REQUEST

Current Zoning: N1-A (neighborhood 1-A)
Proposed Zoning: N2-A(CD) (neighborhood 2-A, conditional)

Approximately 9.24 acres located at the dead-end of Jenkins Avenue and along the west side of Wright Avenue.

The petition proposes to develop up to 93 single family attached residential homes on a vacant parcel located between Walker Road and Craig Avenue, north of Sharon Amity Road.

RZ.03

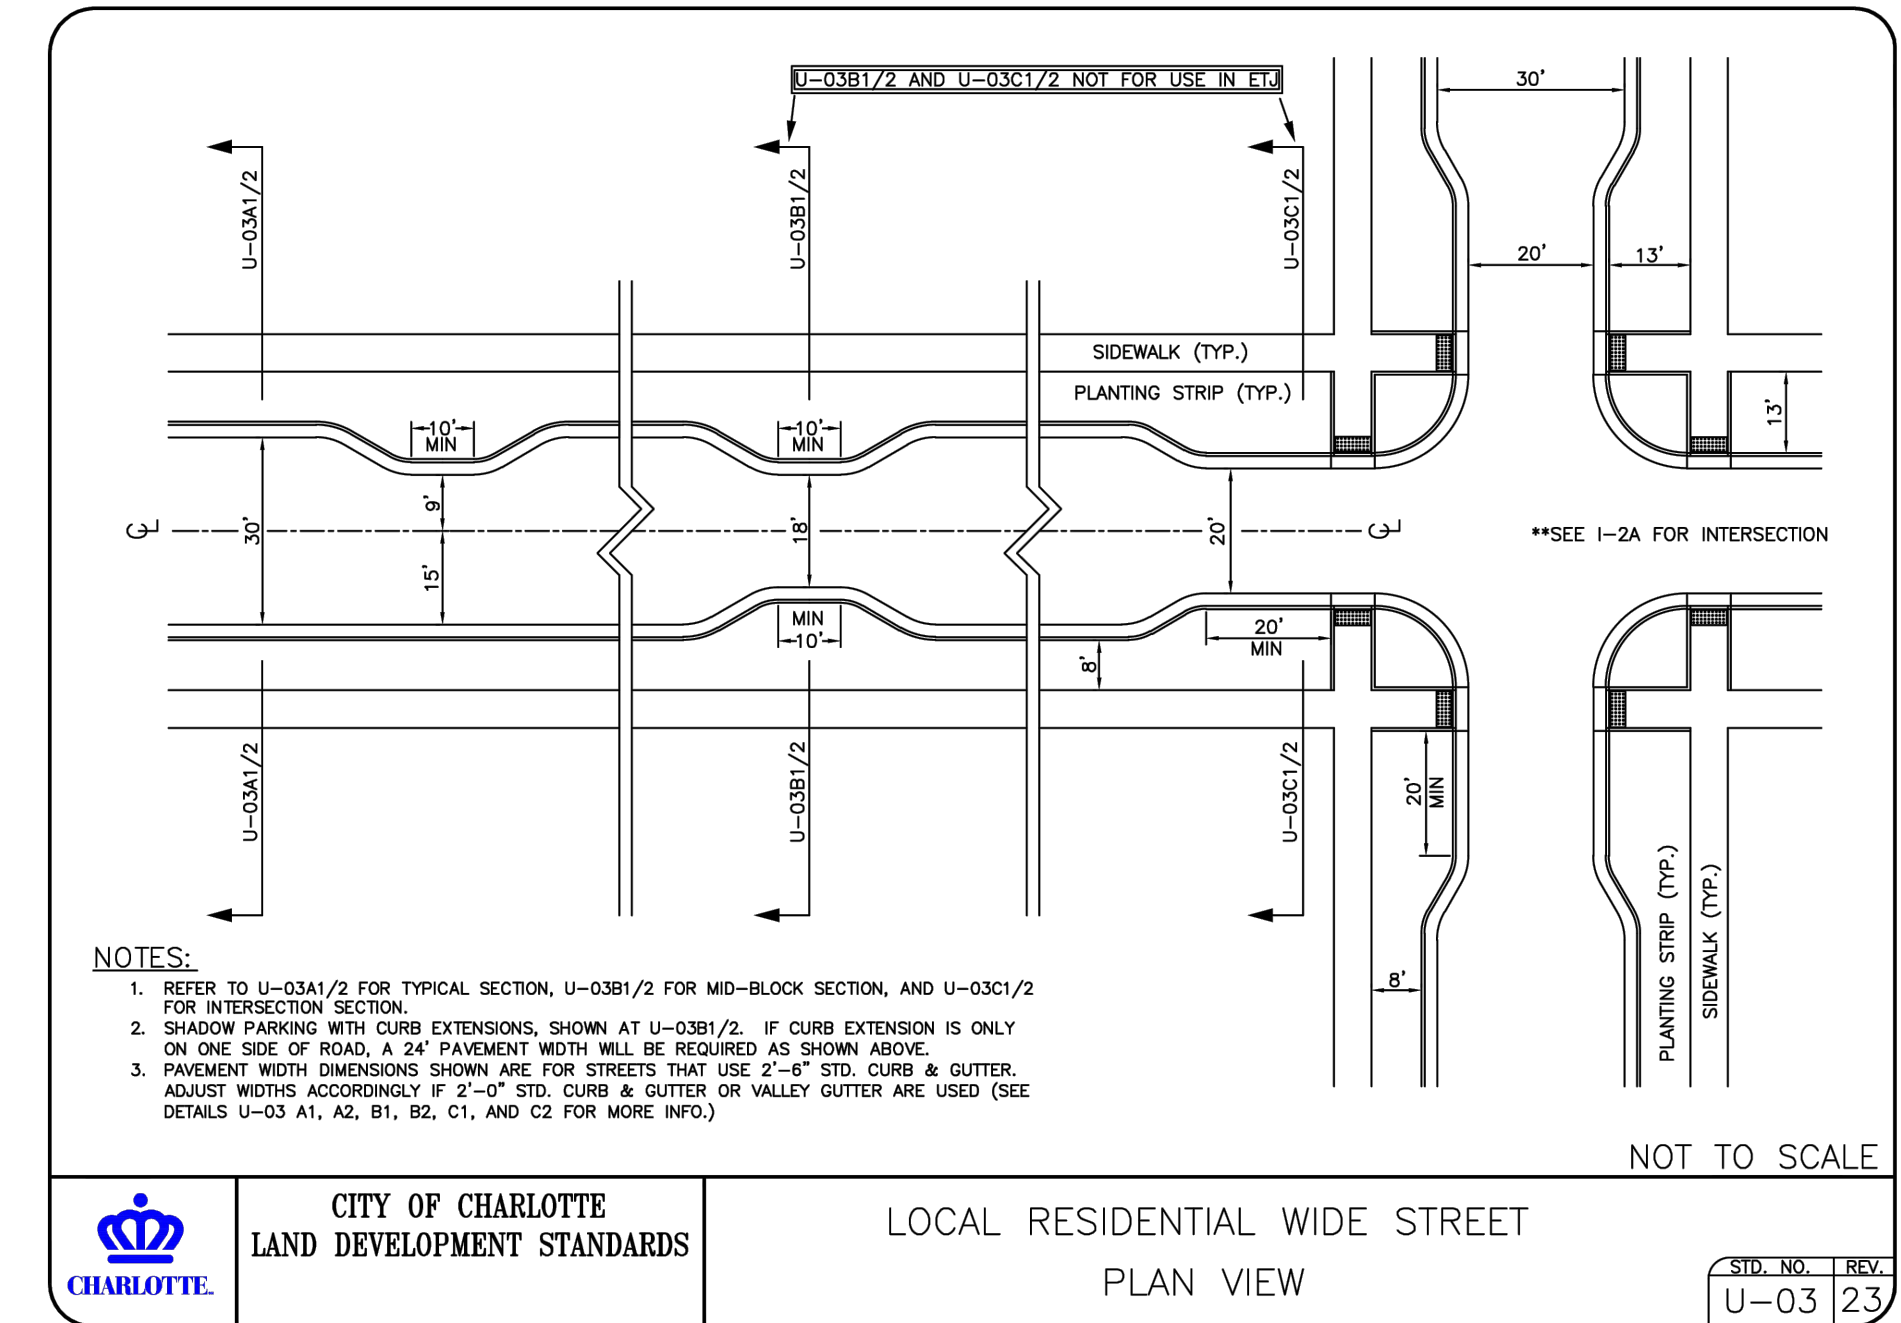
3. ~~Revise site plan to include a temporary turnaround for Street A. Since "Street A" is a dead-end road, this will require a turn-around. See CLDSM 11.18A for reference.~~ **Addressed**
4. ~~CDOT requests that the petitioner commit to upgrading the southern portion of pavement section along Jenkins Avenue east of the proposed development. An existing townhome development is committed to upgrading the northern portion of Jenkins Avenue.~~ **Addressed**

- Specifies improving Wright Avenue as a Local Residential Wide Street.
- Notes principal and accessory buildings will be comprised of a combination of portions of brick, natural stone (or its synthetic equivalent), stucco, cementitious siding, fiber cement (HardiPlank) and/or other materials approved by the Planning Director.

**RZ.01**

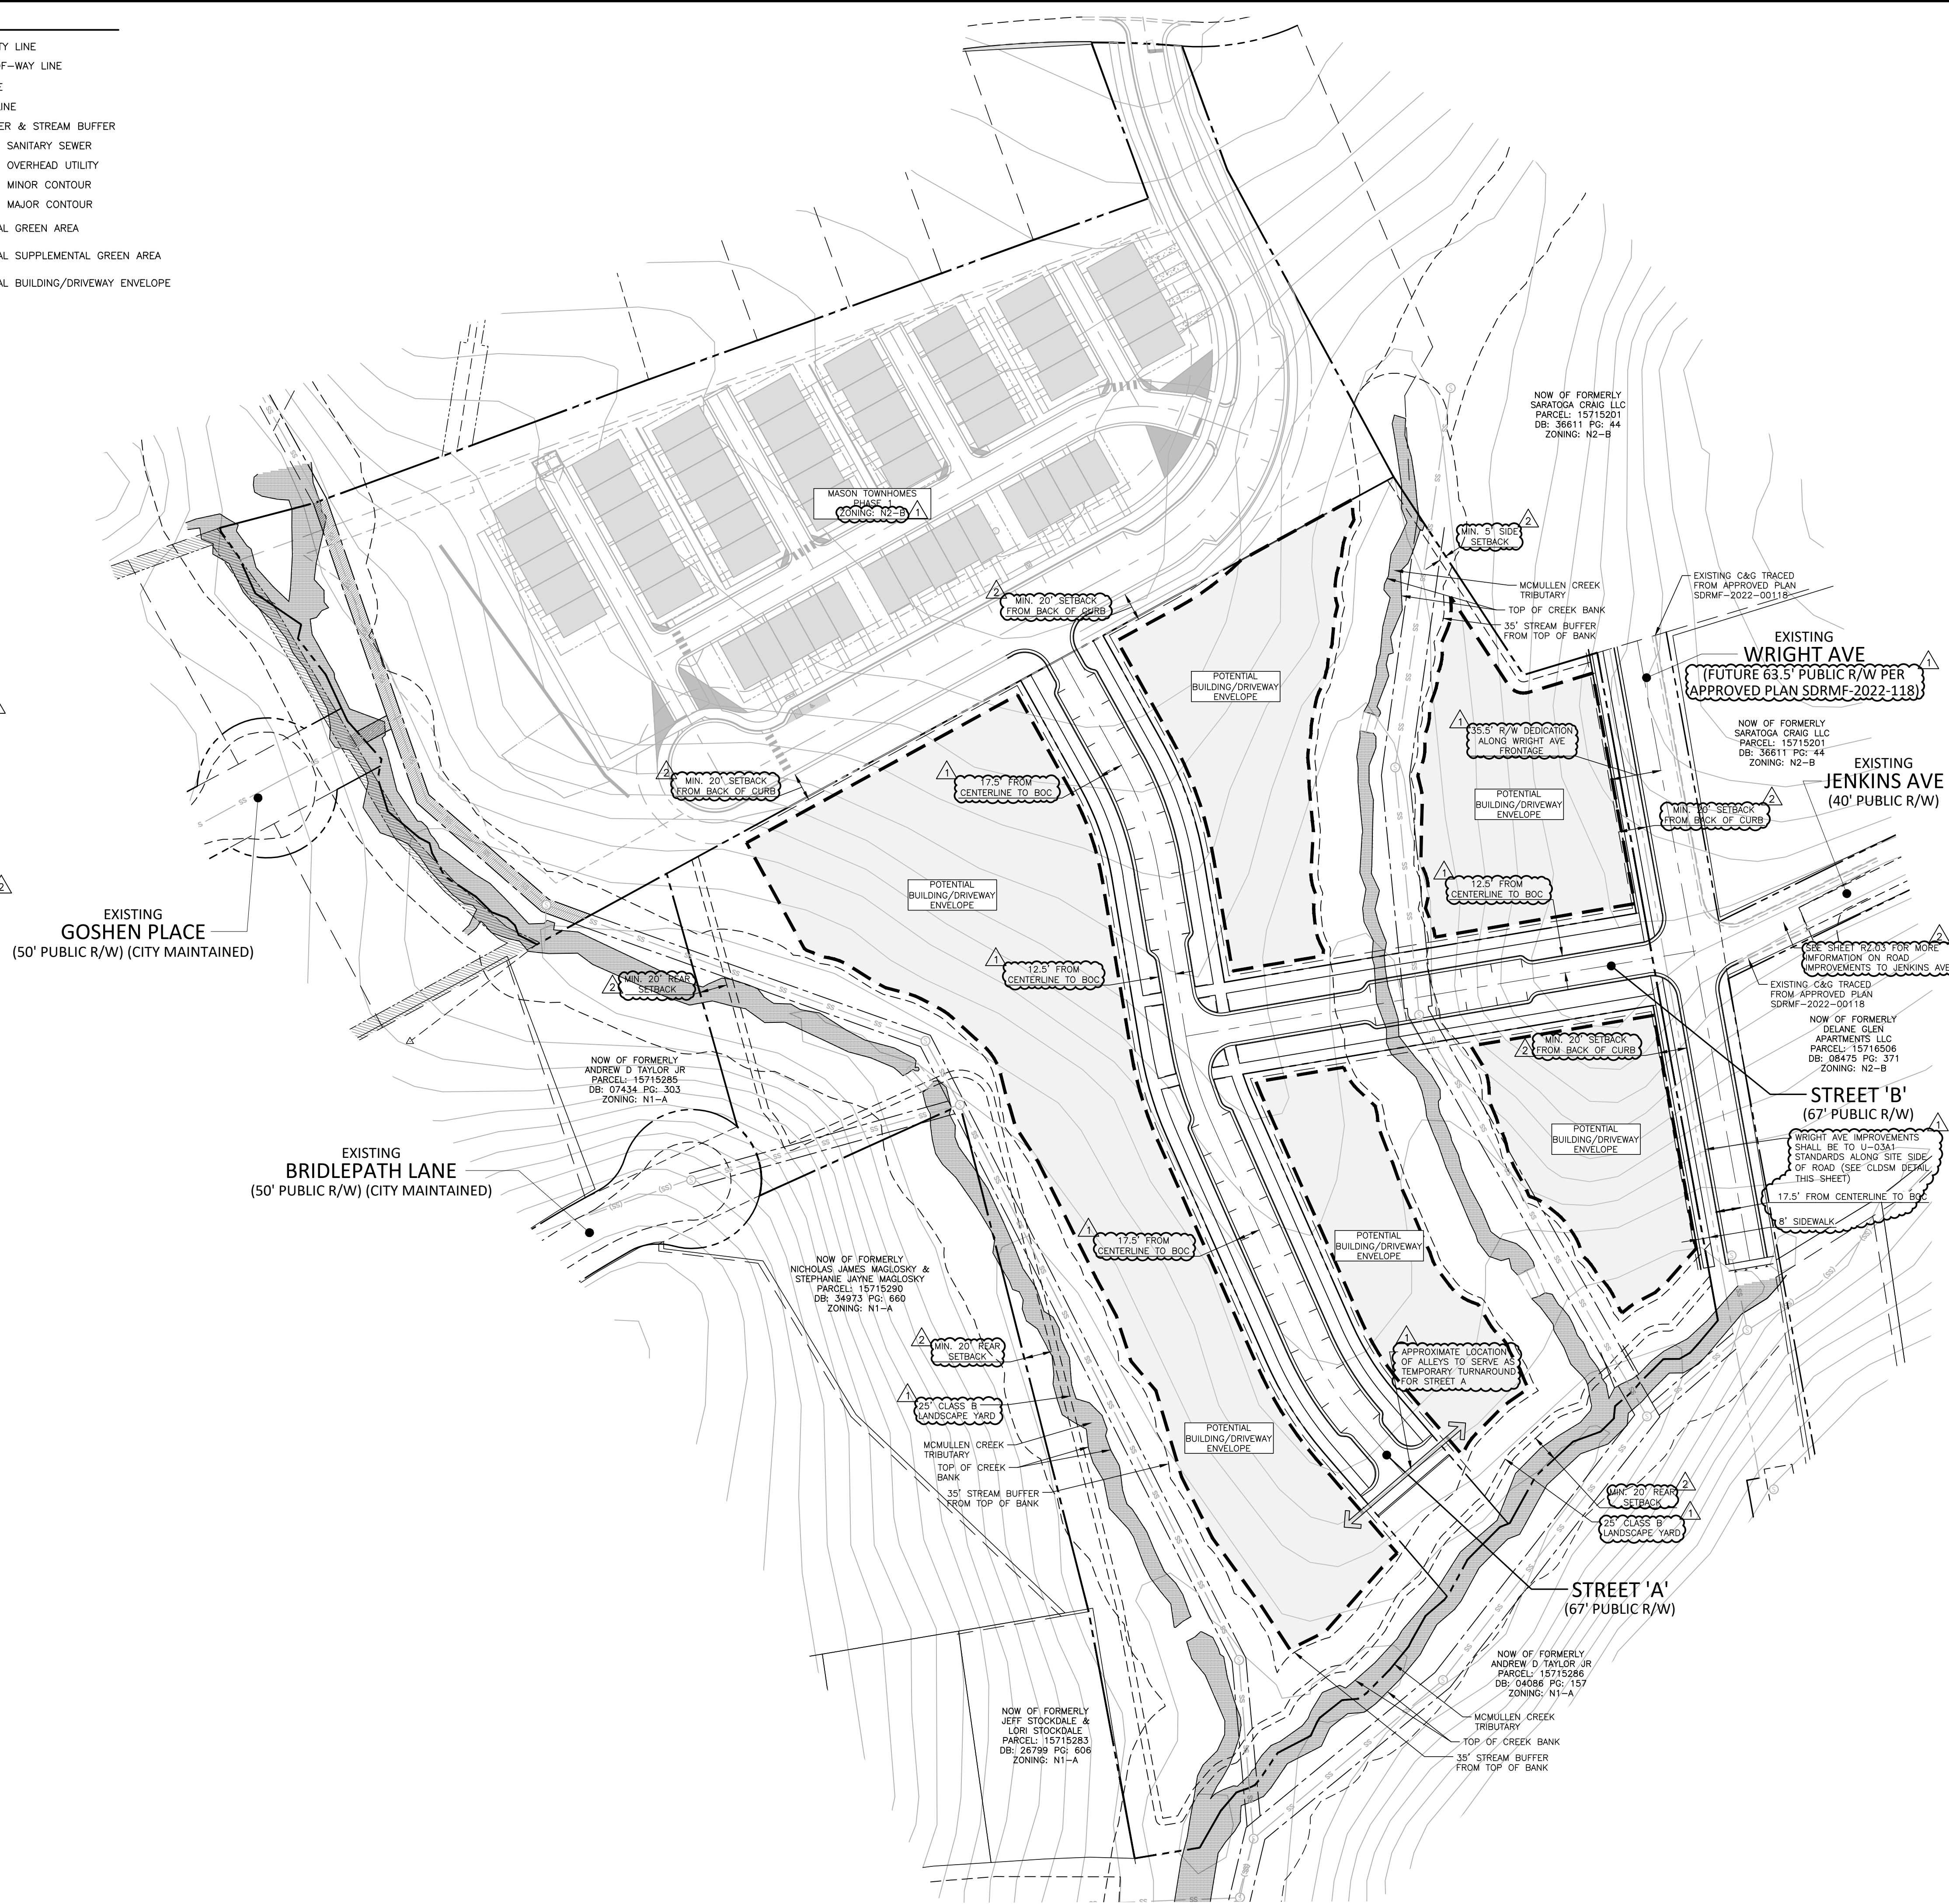
1. ~~We recommend adding the following note under Environmental Features: "Petitioner agrees to provide 100-yr stormwater peak control or provide a downstream analysis using the criteria specified in the SCM Design Manual."~~ **Addressed**
2. ~~Green area is broken up into too many sections (max of 3) Please review the Charlotte Tree Manual for guidance. Update: Tree save areas are not shown on the site plan. Protected tree save must be minimum 30-foot width.~~ **Addressed**

5. ~~Please confirm if the petitioner is removing the public path to Bridlepath Lane.~~ **Addressed**
6. ~~Recommend improving Jenkins Ave to public street standards so that it can be publicly maintained. Coordinate with the project SDRMF-2022-00118 Jenkins Townhomes to improve Jenkins Ave to public street standards.~~ **Addressed**
7. ~~Clearly label streetscape along Wright Avenue and commit to all streetscape improvements in development notes.~~ **Addressed**
8. ~~New Outstanding Issue: If these are going to be on sublots, please provide architectural standards. Addition of porches/stoops, recessed garage doors with transparency, and other elements will enhance elevations fronting the street and the pedestrian realm.~~ **Addressed**

- ~~Illustrates an eight-foot path between Linda Lane to the proposed development.~~
- Commits to construction of a minimum eight (8) foot sidewalk and eight (8) foot wide planting strip along the site's frontage of Wright Avenue.

- Adds the following note: "The petitioner will work in good faith with owner of 15716506 to repave a portion of the existing pavement along Jenkins Avenue, per the attached outlined in red, for maintenance acceptance by CDOT. Per approved SDRMF-2022-00118, the owner of 15715201 is responsible for improvements to a portion of Jenkins and Wright Avenues."

- Illustrates 25-foot Class B landscape yard along portions of west and south property lines.
- Notes development within the SWIM/PCSO buffer shall be coordinated with and subject to approval by Charlotte-Mecklenburg Storm Water Services and mitigated if required by city ordinance.
